Our Ref: MA08365-1

Date: 1 September 2010

RE: PREFERRED PROJECT REPORT – WALLACE WURTH BUILDING (MP 09_075)

GFA LOWER GROUND: 2,262 m² 1 Lower Ground Floor 1:400

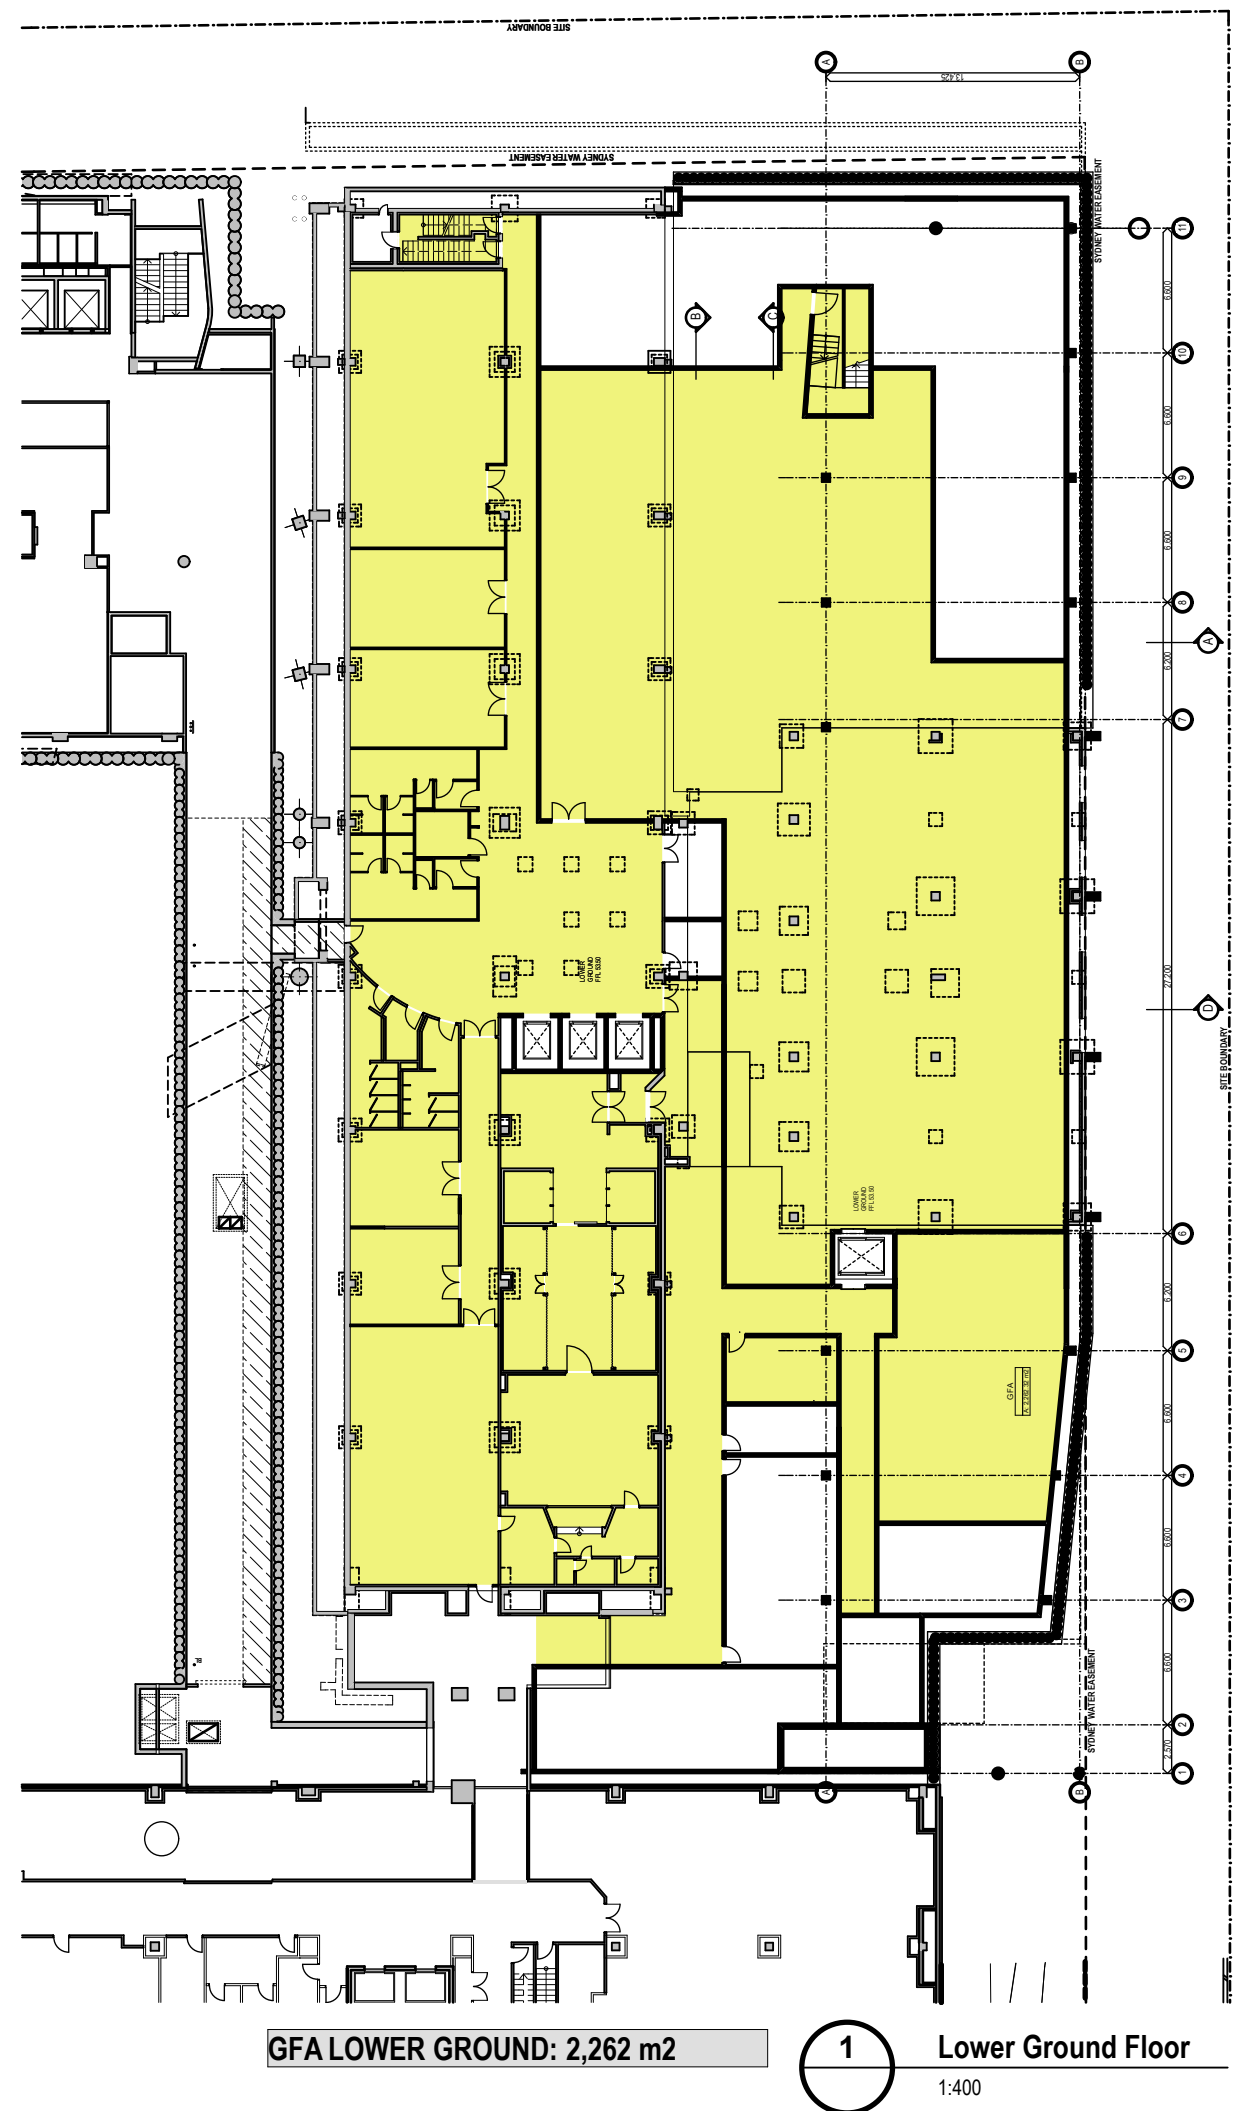
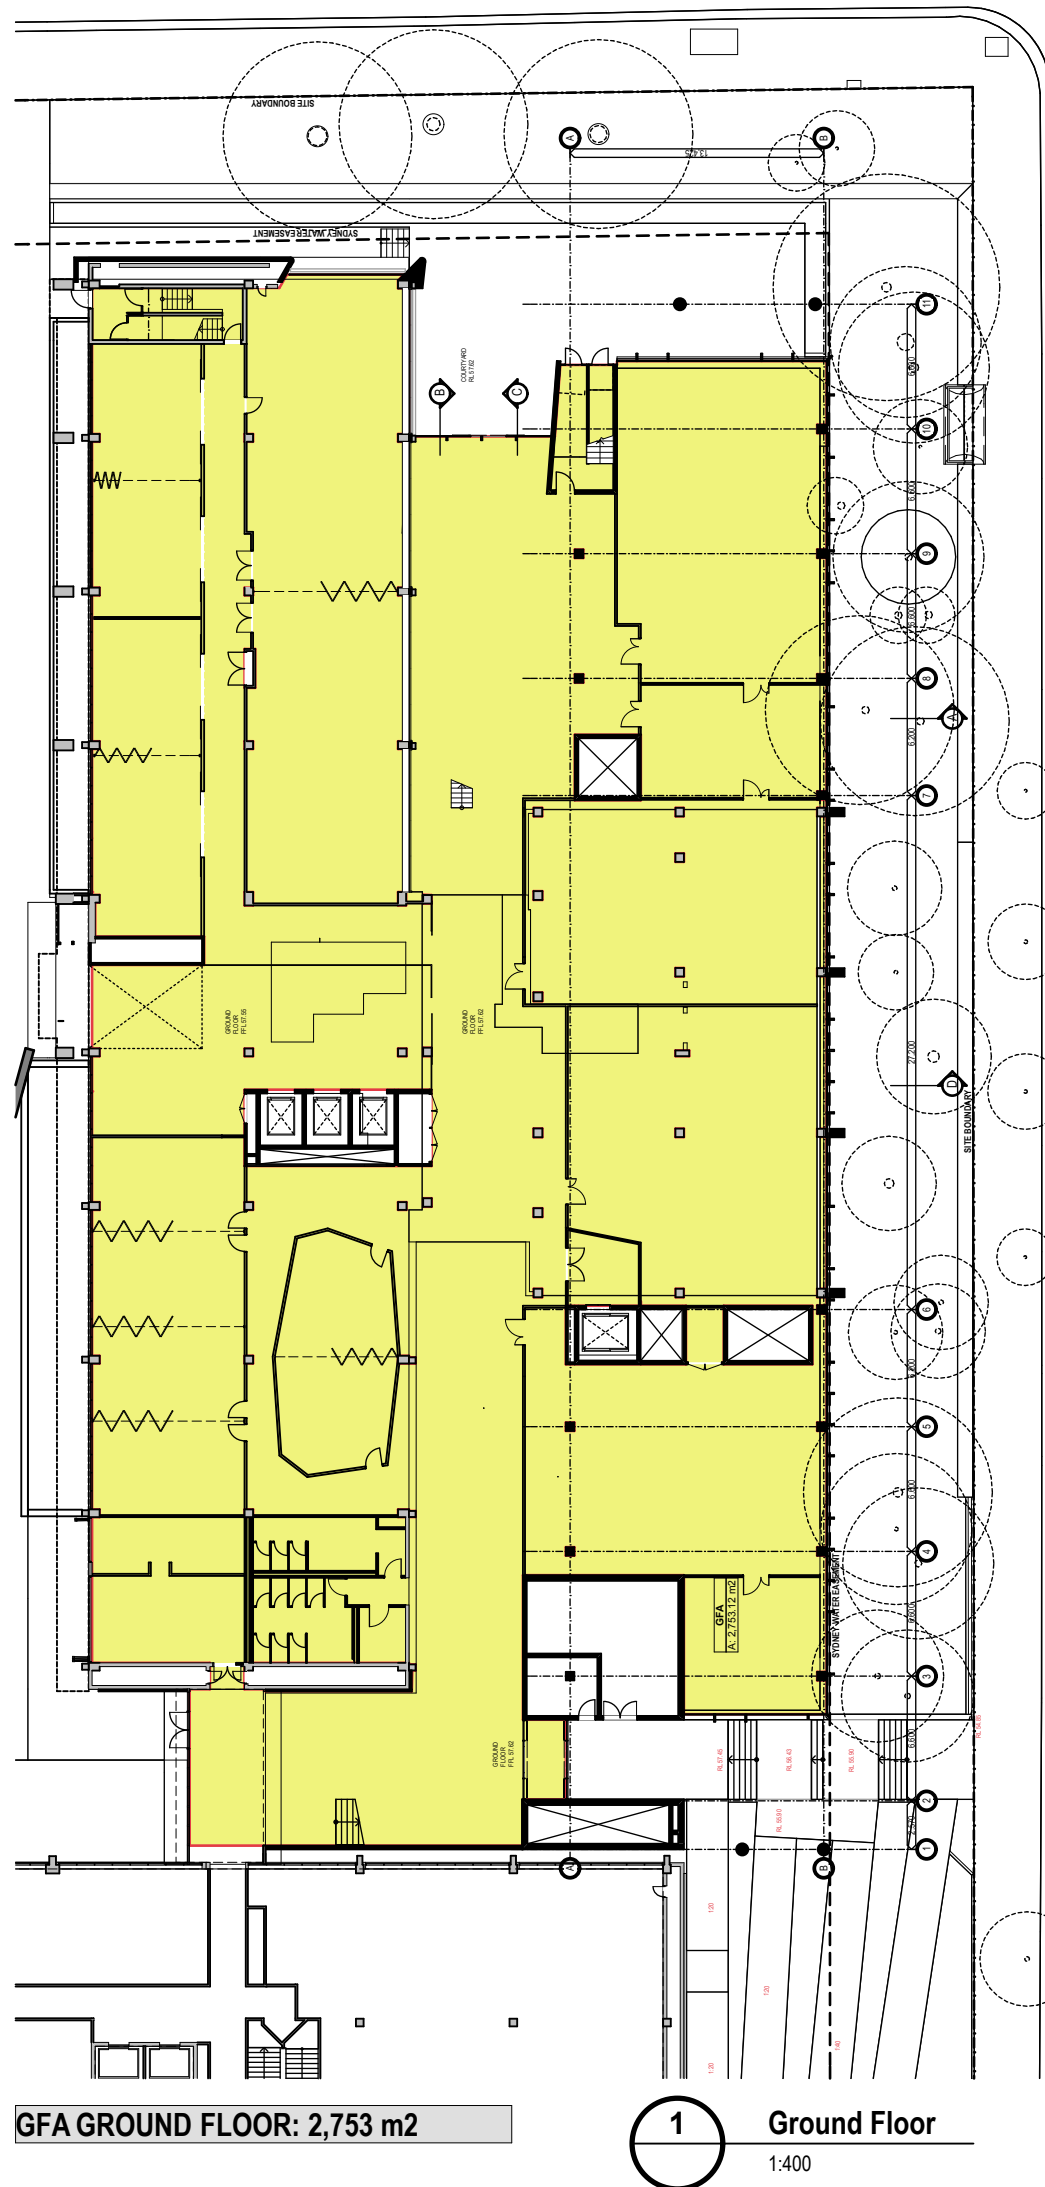
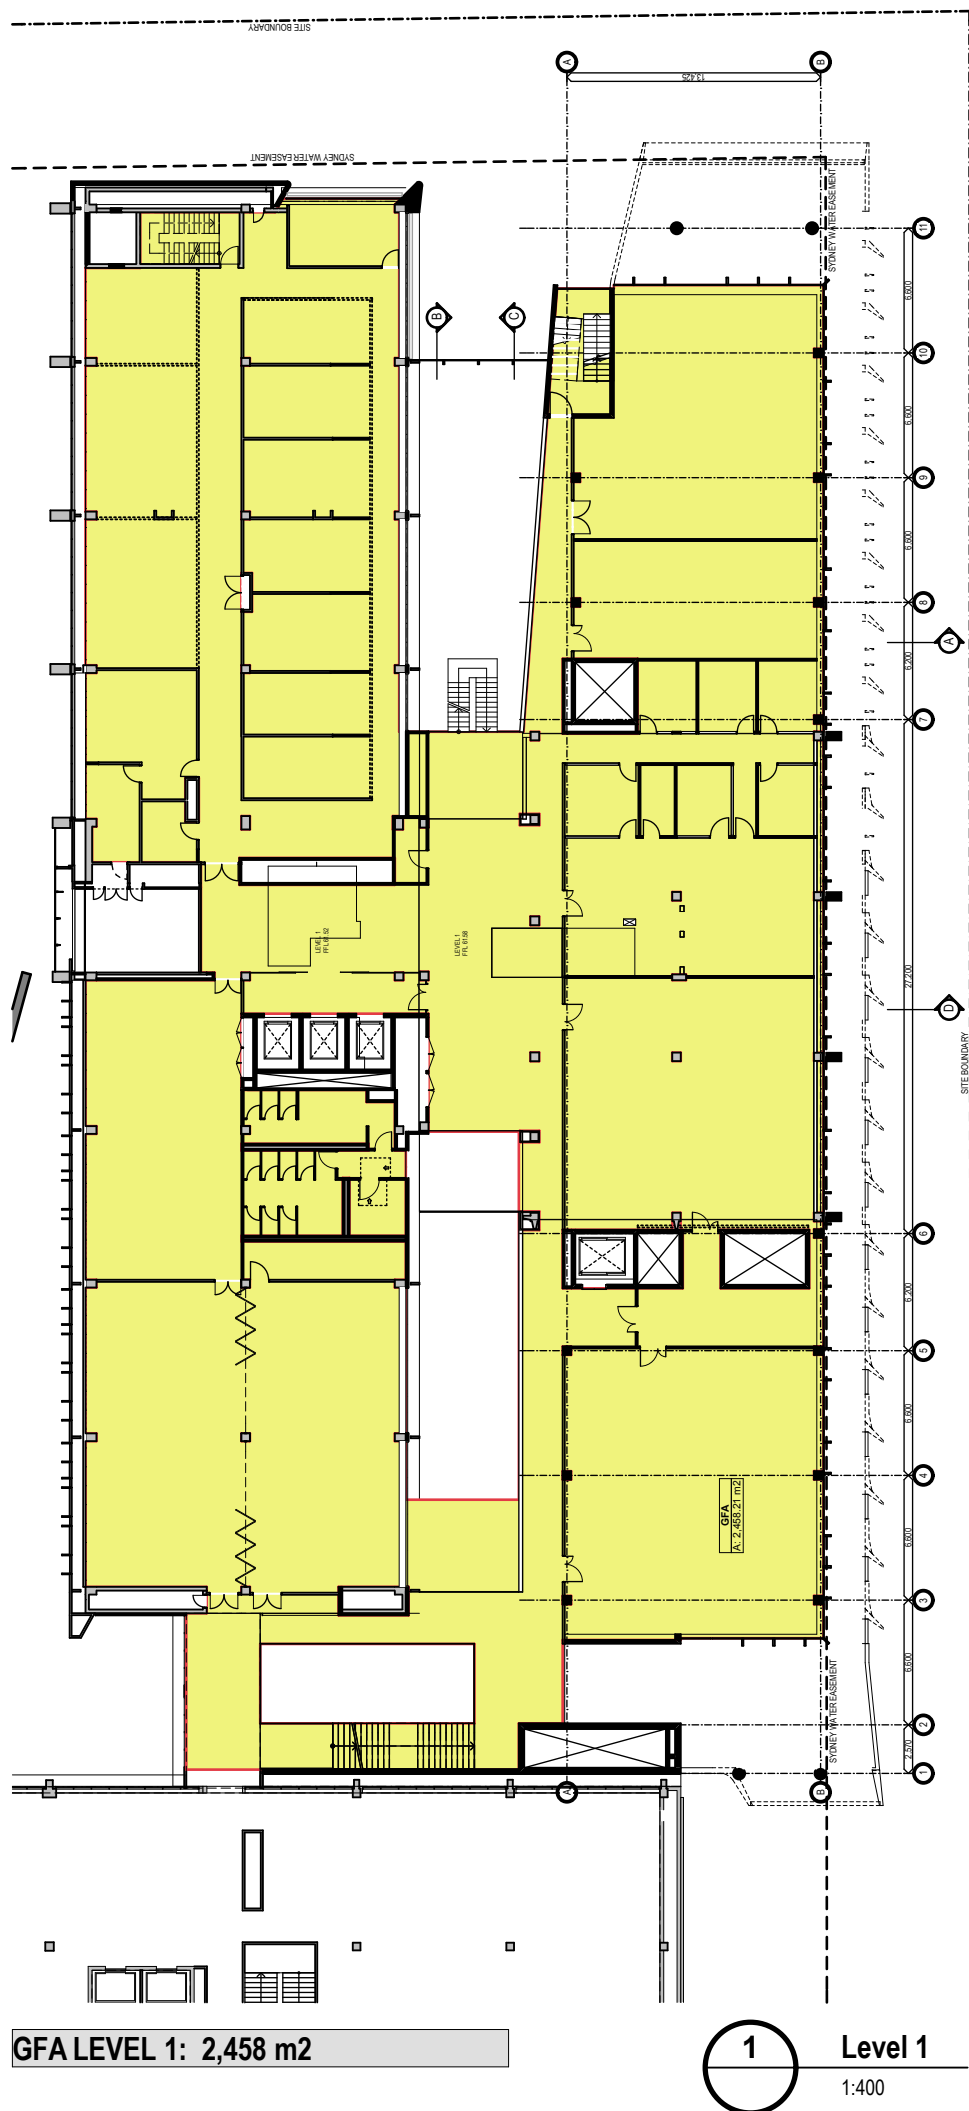
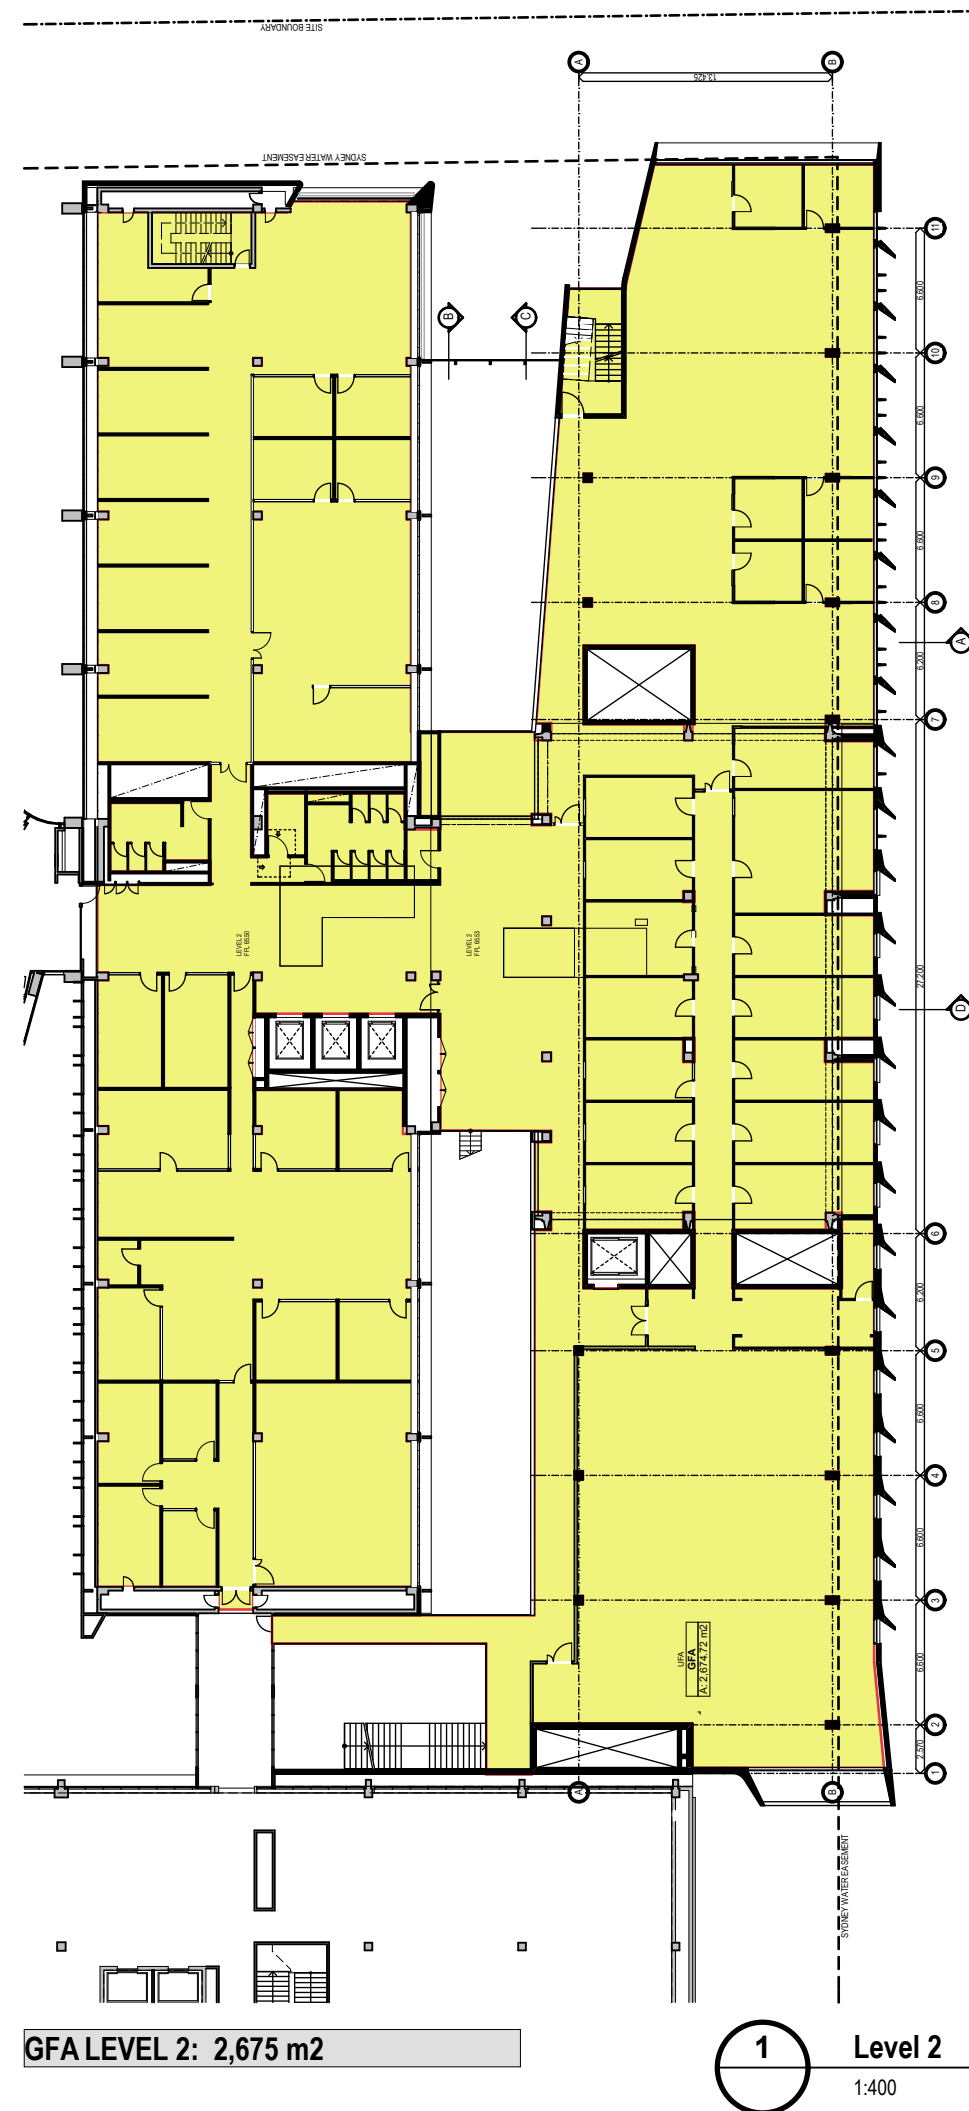
Some minor amendments have been incorporated into the overall design of the building. These include amendments to the atrium within the southern section of the proposed building, minor changes to accommodate a fire stair to the lower ground floor and some subtle changes to the north and east elevations (refer amended plans in **Attachment 4**).

The design amendments for this part of the atrium propose to reduce its height to Level 3. A new façade “skin” is proposed on those parts of the Biological Sciences building that would be visible from within the proposed Wallace Wurth Building following the amendments to the atrium (i.e. the ground floor, level 1 and level 2).

The new atrium roof will comprise a concrete slab, overlain with a membrane and stone ballast to enable drainage. Skylights are also proposed along the southern boundary adjoining the Biological Sciences Building to maximise solar access to the levels below.
